# **M42 Junction 6 Development Consent Order Scheme Number TR010027**

## **8.100 Applicant's Comments on any Additional Information or Submissions Received by Deadline 9**

**Applicant's Comments on any Additional Information or Submissions  
Received by Deadline 9**

Drawing Title
**FIGURE 8.7
VIEWPOINT C
LANDSCAPE VISUALISATION
SHEET 1 OF 9**

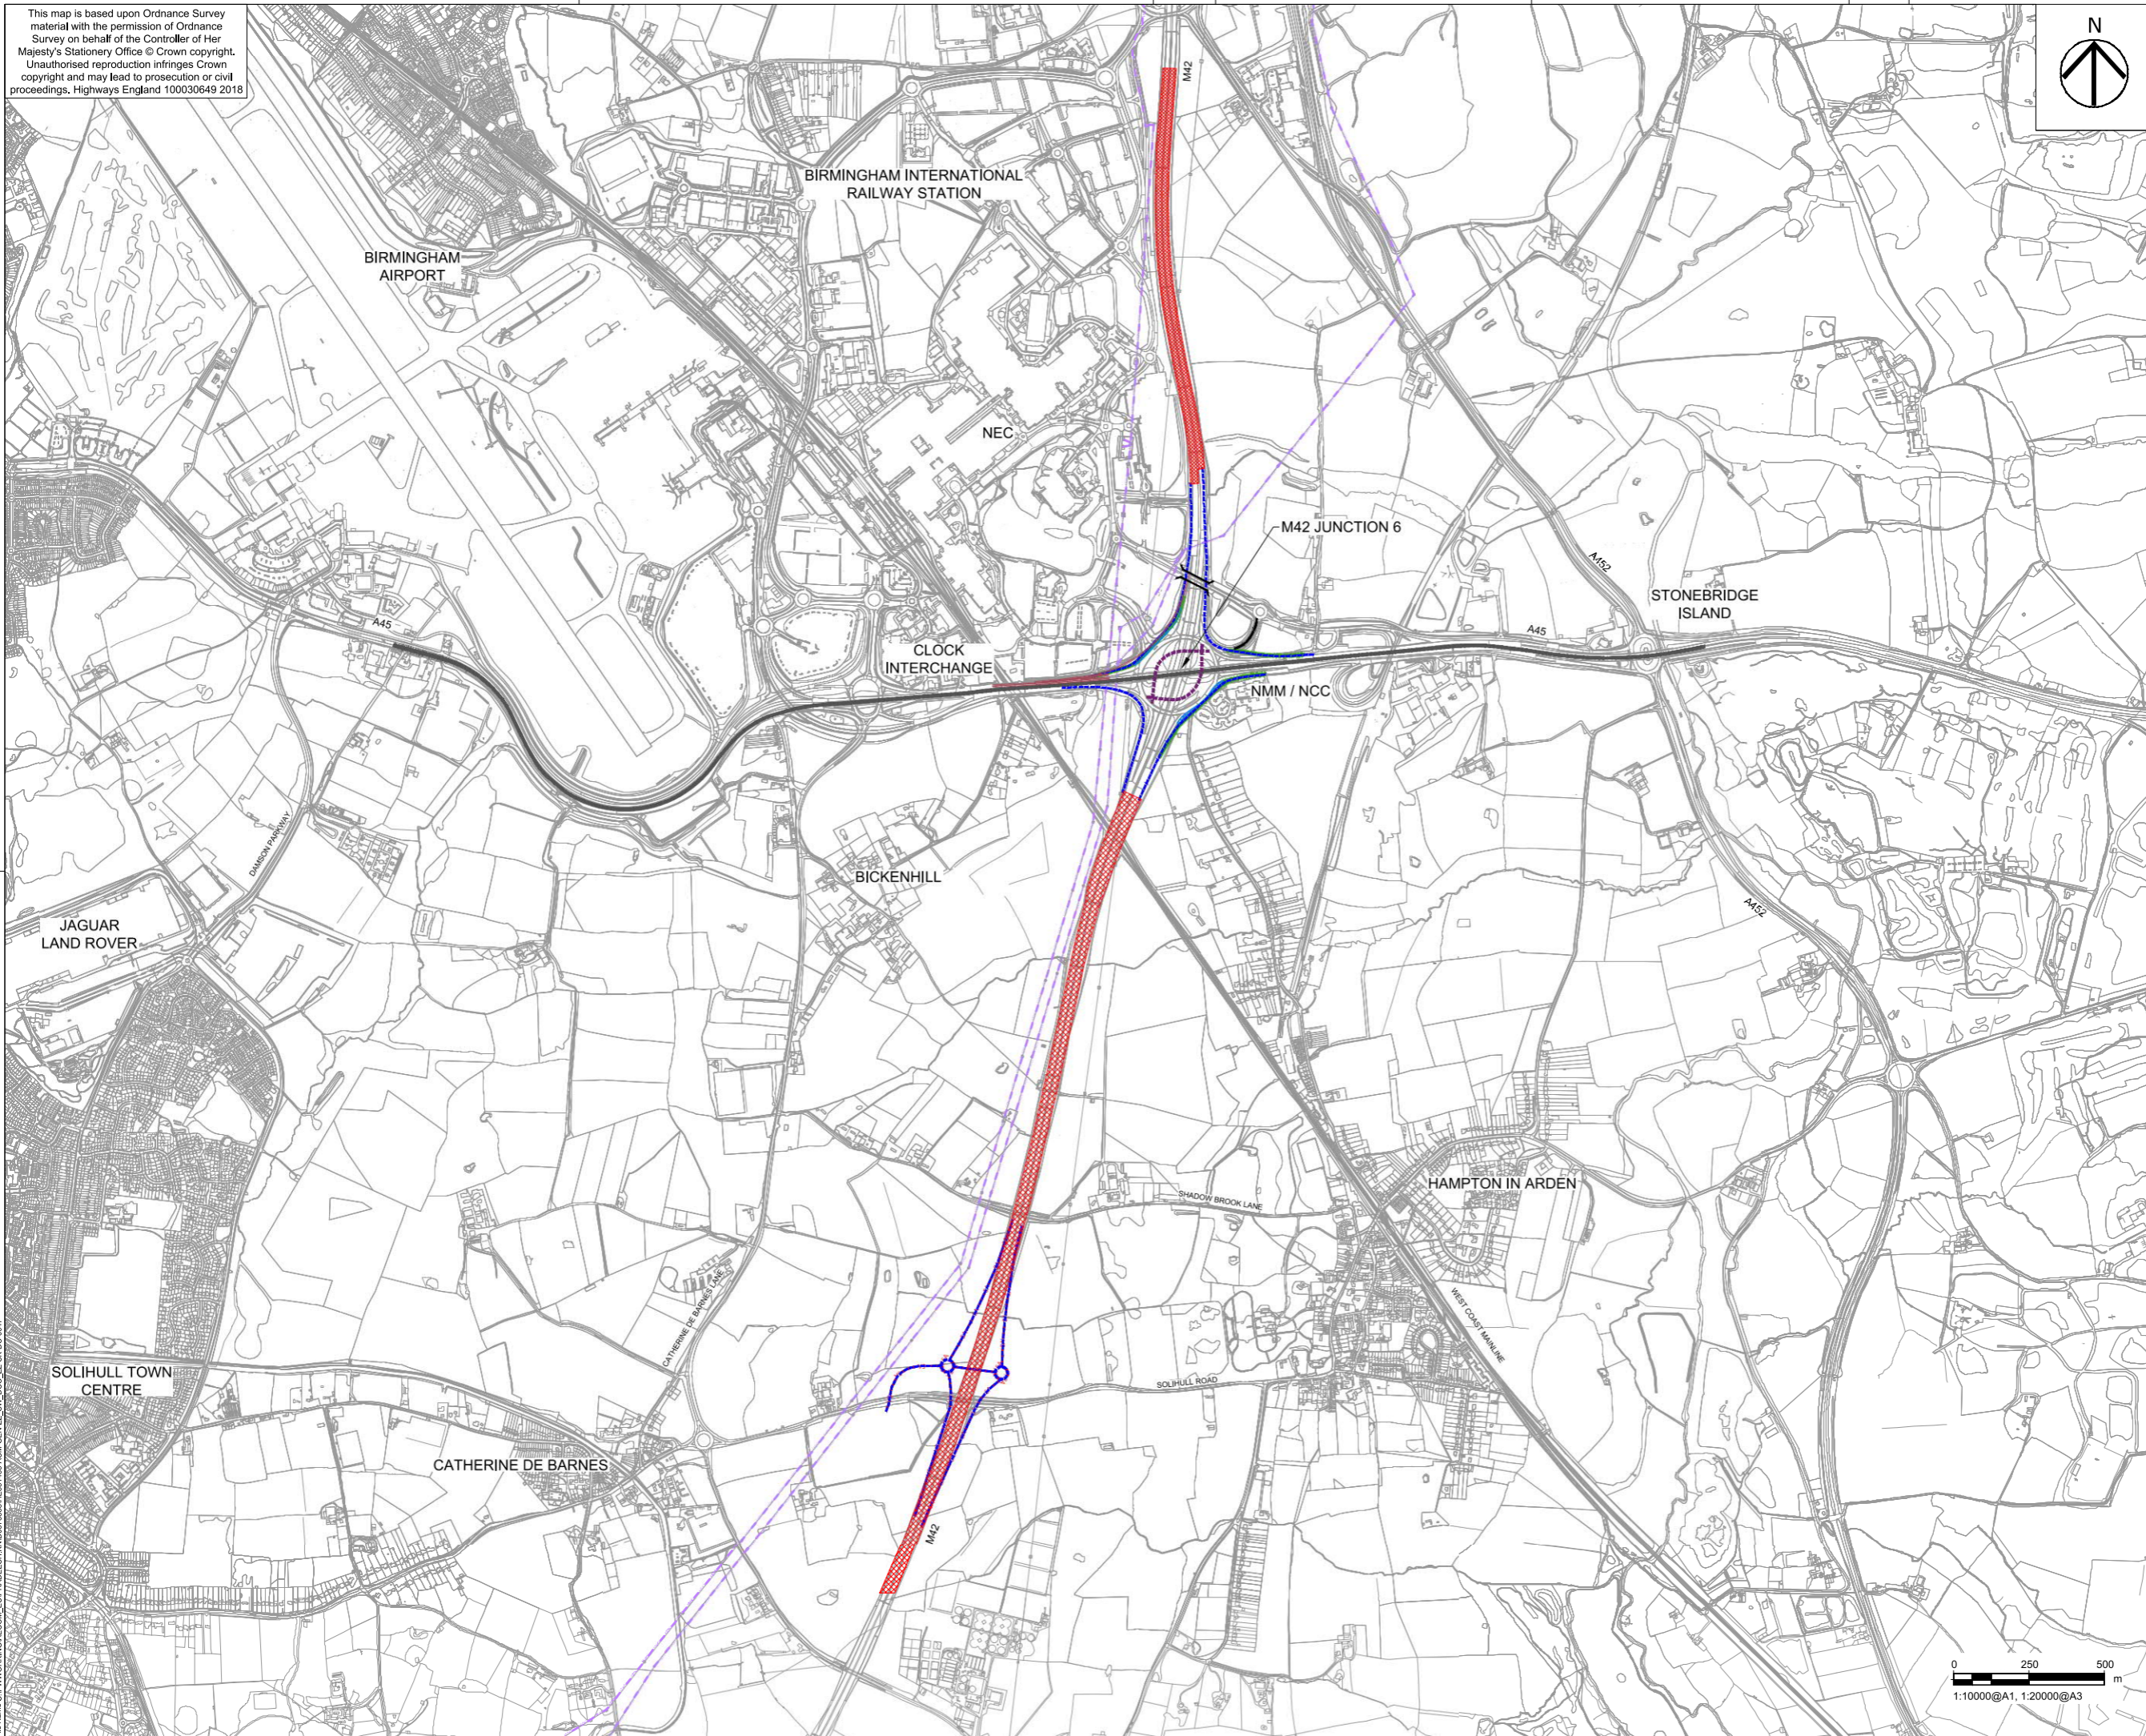
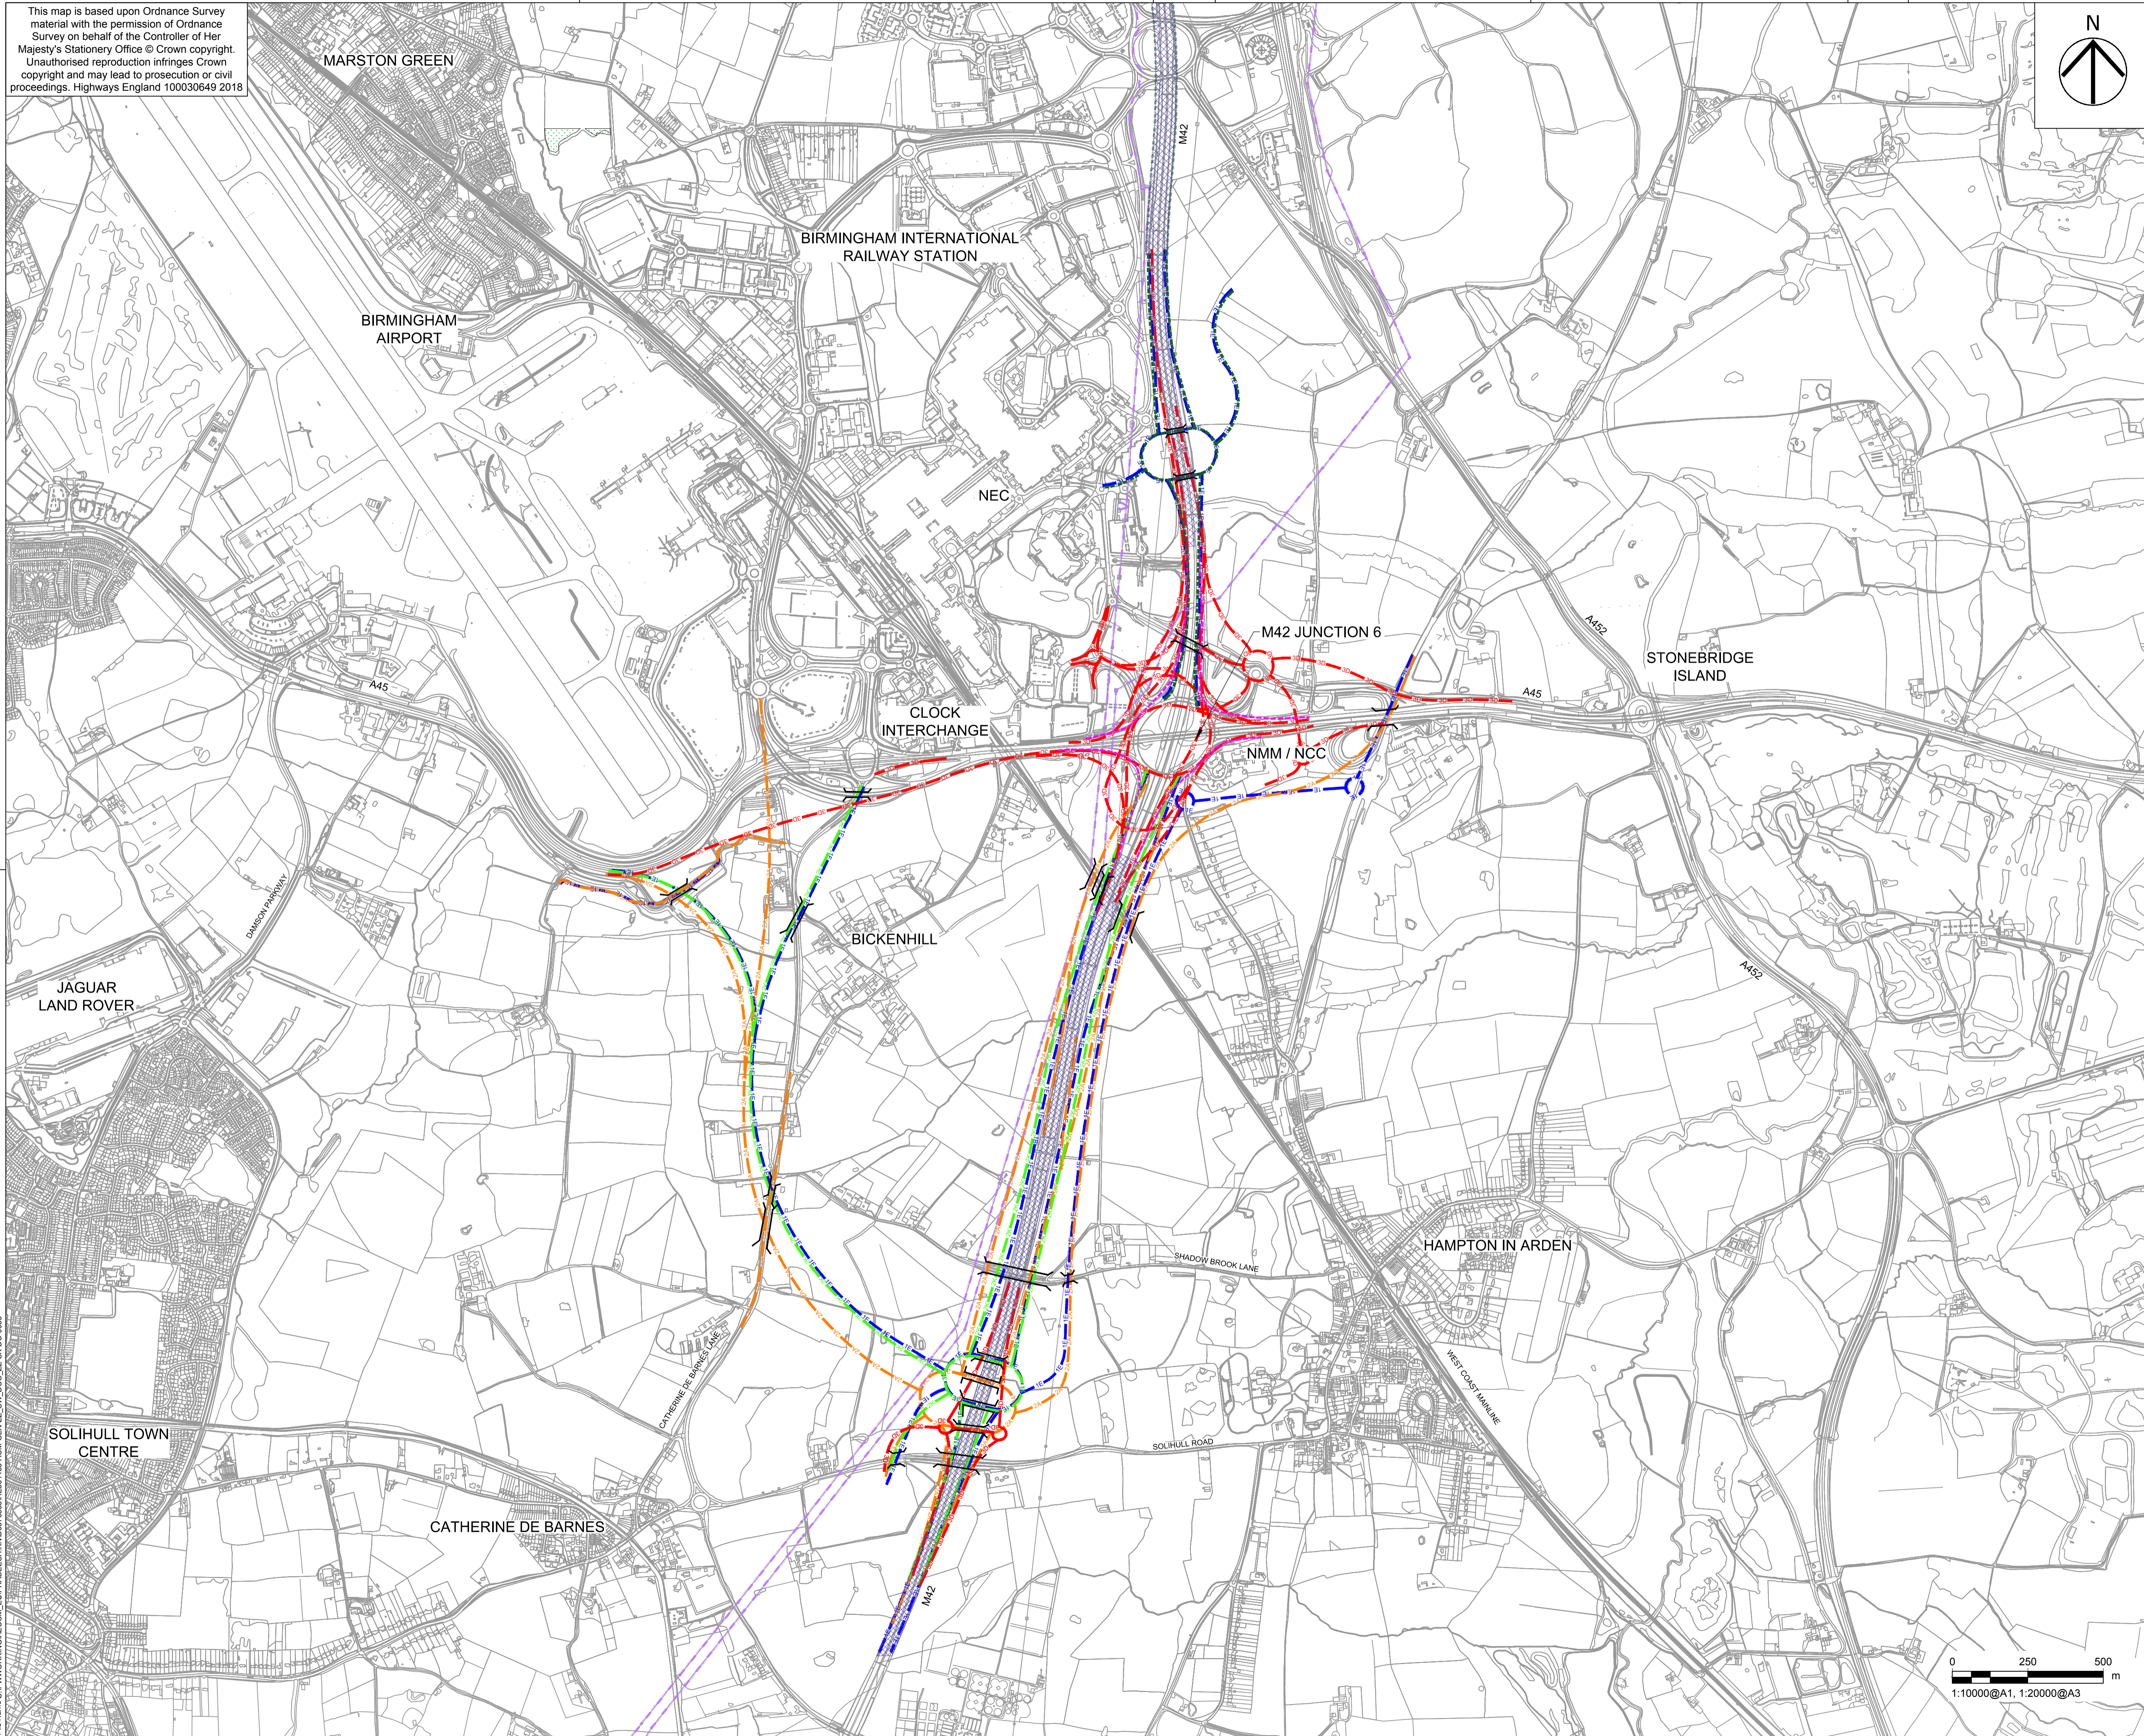
Submitted by	Title	Comments	
Philip O'Reilly	Responses to any Further Information Requested by the Panel	4.3	<p><b>Philip O'Reilly comment:</b></p> <p>The views from my property to the north-east, the east and the south-east will be dominated by the proposed Mainline link road, the proposed realigned Catherine de Barnes Lane, the proposed overbridge, the proposed 'Barber's Coppice Roundabout' and the proposed Merge Slip from 'Barber's Coppice Roundabout' to the proposed Mainline link. However, HE did not think a visualisation of the landscape and visual impact on my property would be representative "to illustrate how the Scheme would likely appear in close proximity, mid-distant and long-distance views across the study area". Instead HE have provided a visualisation from viewpoint R, which shows a close-proximity view of the lower edge of the 'Catherine de Barnes South Overbridge'; a view that does not show how the overbridge sits within the landscape.</p> <ul style="list-style-type: none"> <li>• It is beyond belief that none of the viewpoints HE have chosen as "representative" include a visualisation of 'Barber's Coppice Roundabout' and the surrounding area.</li> </ul> <p><b>The Applicant response:</b></p> <p>Visualisation locations are chosen to be representative and proportional to the assessment of a proposed scheme and to illustrate how the Scheme would likely appear in close proximity, mid-distant and long-distance views across the study area. These are agreed with SMBC. A visualization at viewpoint EE would not provide any further understanding of the impact of the Scheme in this location, as the landscape assessment as presented within Chapter 8 [APP-053/Volume 6.1] of the Environmental Statement already states a large adverse effect at this viewpoint would occur.</p>
